# Planning Response Report To An Coimisiún Pleanála ACP-323742-25 – Proposed Extension to Drumcliff Burial Ground, Ennis, Co. Clare

Client: Clare County Council  
Project Number: 7421  
Issue: A

CURRENT ISSUE			
Issue No:	Date: 19.2.26	Reason for issue: Response to third party submissions	
Sign Off	Originator	Checker	Approver
Print Name	Mandy Coleman	Jackson Coleman	Mandy Coleman

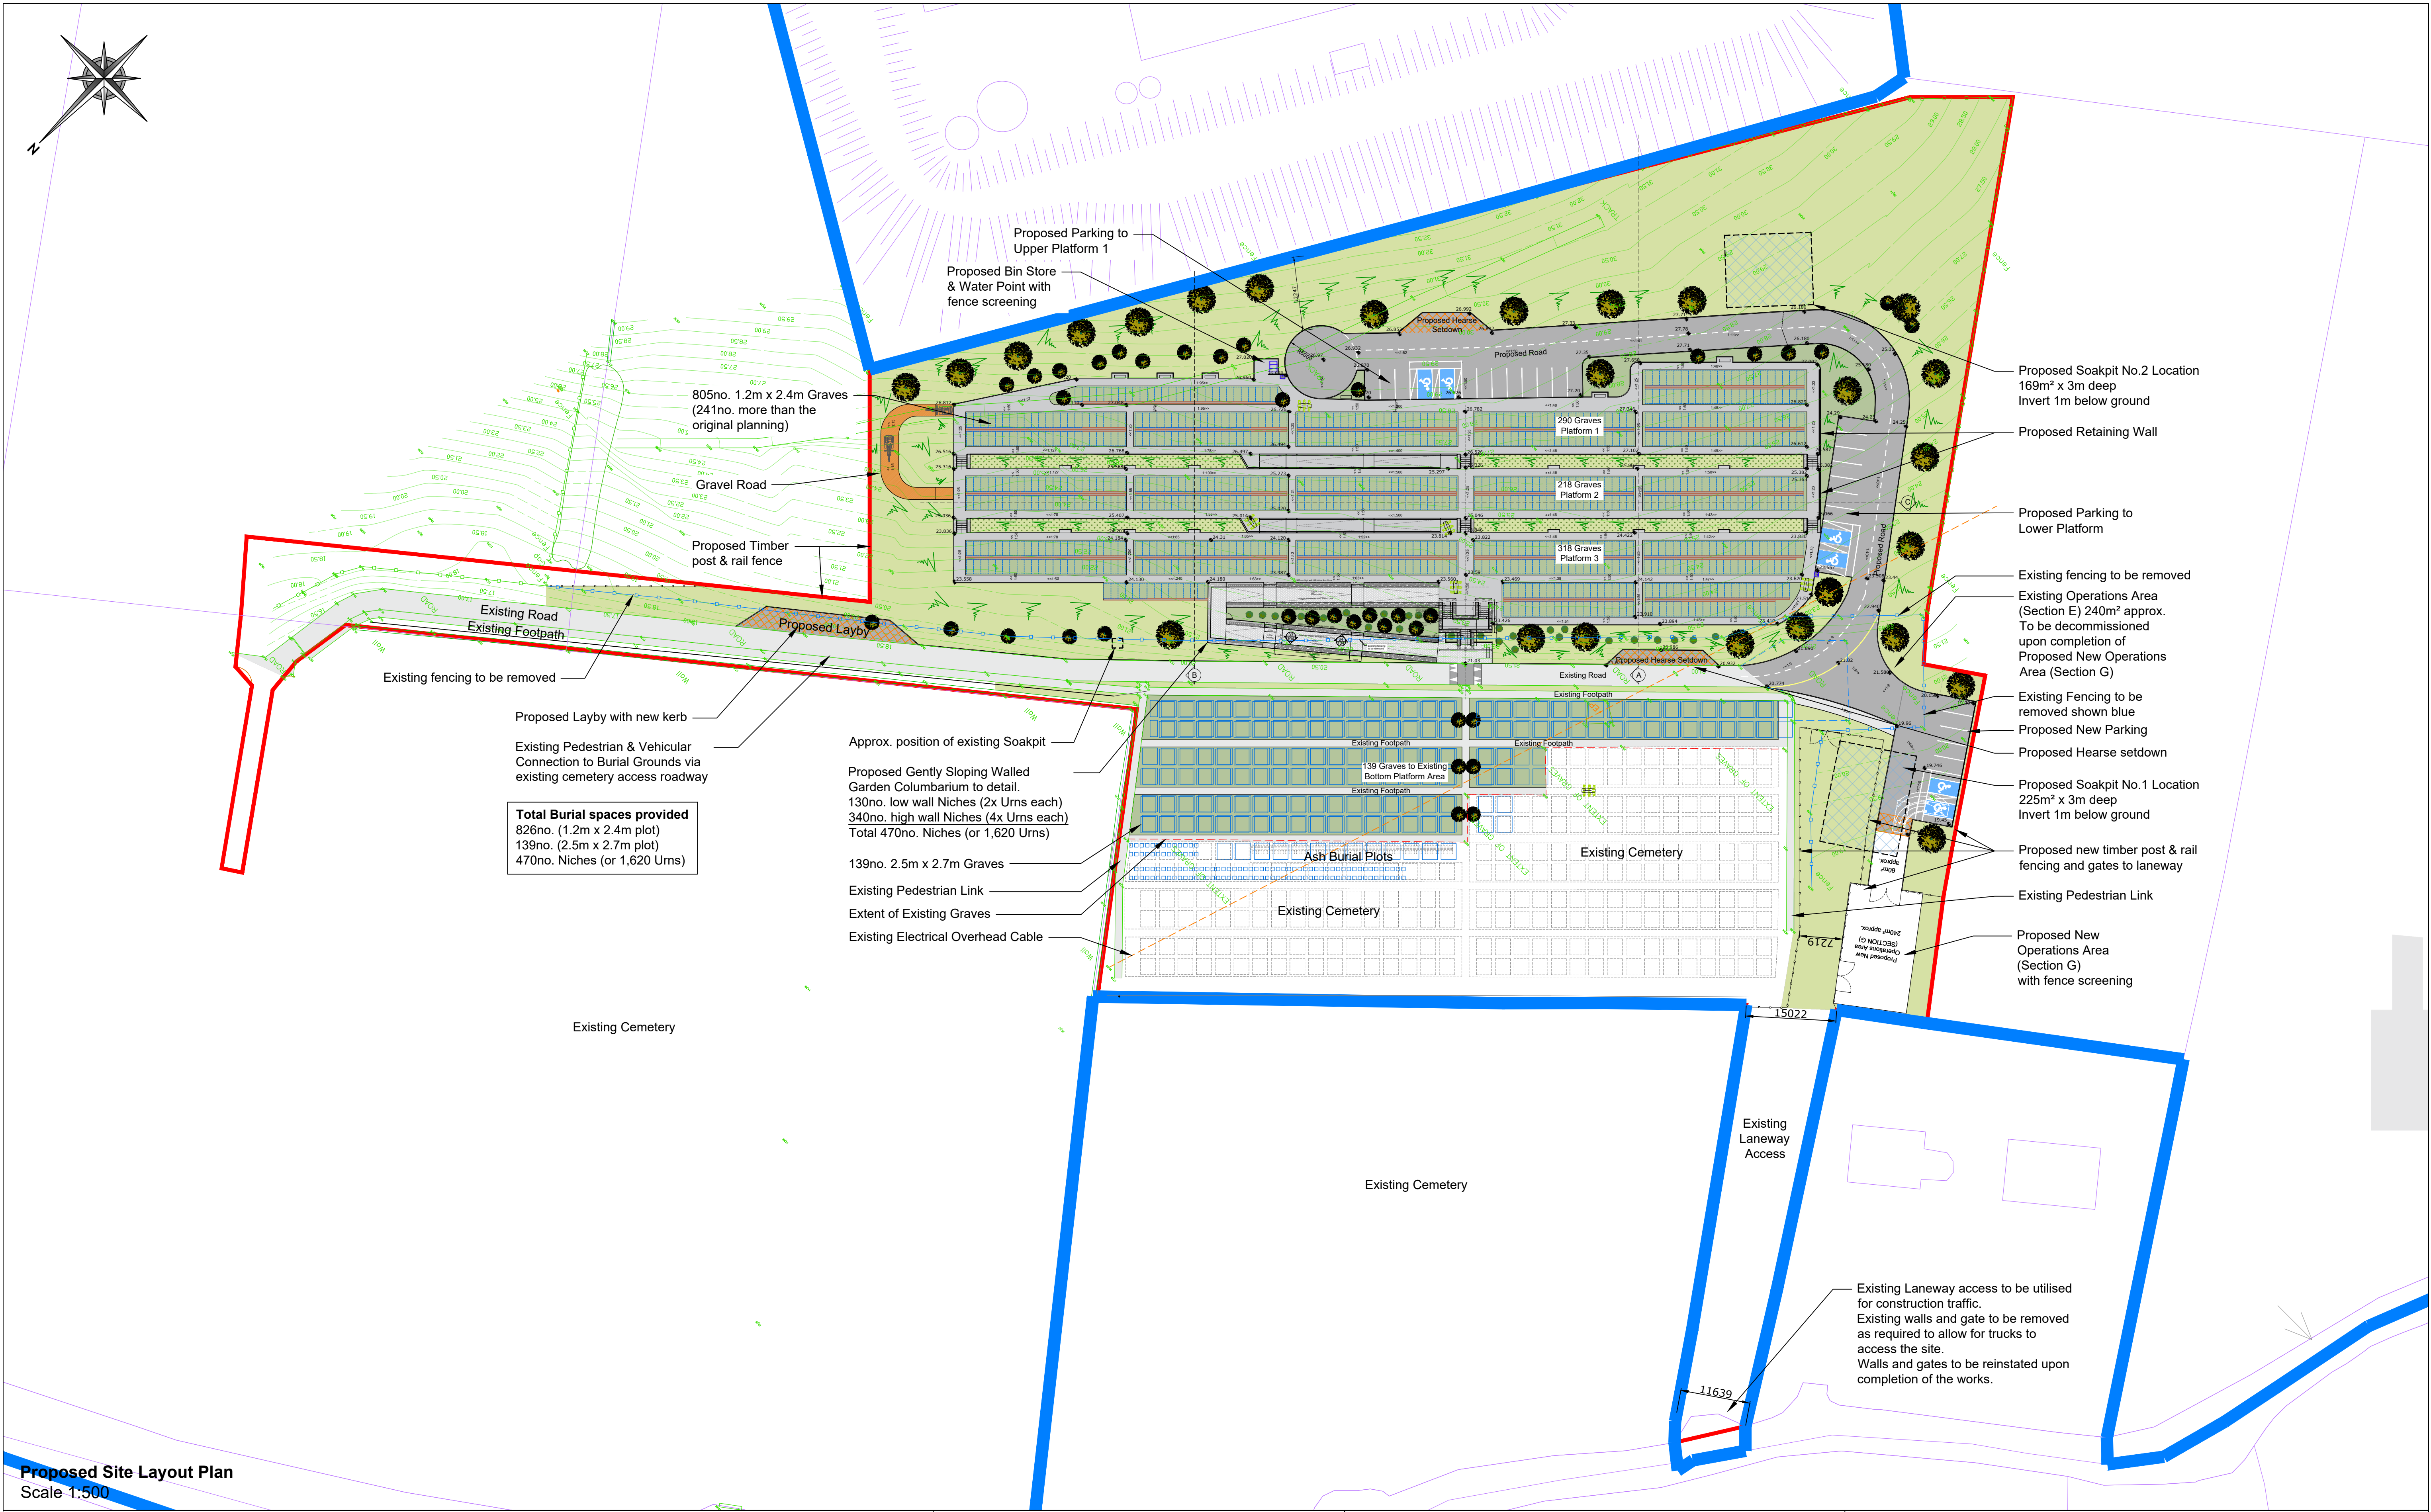
Concerns relating to flooding of the public road and adjoining lands, and the adequacy of the proposed drainage/soakaway design, were raised in the observations from Robert Behan, Pat Tierney and Dermot Queally.

These matters are addressed in the Civil Engineering Response prepared by PC&A, which confirms that the drainage design for the proposed burial ground extension has been developed in accordance with SuDS principles and the objectives of the Clare County Development Plan 2023–2029 (including Objective CDP2.11(c)), to ensure that stormwater generated within the development is appropriately managed on-site. The drainage strategy provides for infiltration of rainfall over green/grave areas, with footpaths graded to direct runoff to adjacent green areas where possible. Surface water from impermeable footpath areas is to be intercepted via ACO drainage channels and directed to soakpits. In addition, surface water from the proposed internal roadway is to be managed by a French drain incorporating a land drain pipe, with a soakpit provided at the lowest point of the drainage run to accommodate heavy flows in excess of that which can be absorbed by the drain itself. The main pedestrian access ramp/stairs (non-porous finish) and the gully serving the existing/proposed roadway junction are also to discharge to a soakpit.

PC&A Response confirms that the sizing and capacity of the soakaway/soakpit system has been informed by trial pitting and five no. BRE Digest 365 compliant soakaway tests, and that the soakaways have been sized by a competent consulting engineer to accommodate runoff from the proposed extension. The drainage system is to be managed and maintained for the operational life of the development, with routine inspection/cleaning of SuDS features to ensure ongoing performance; a planning condition ensuring this can be attached.
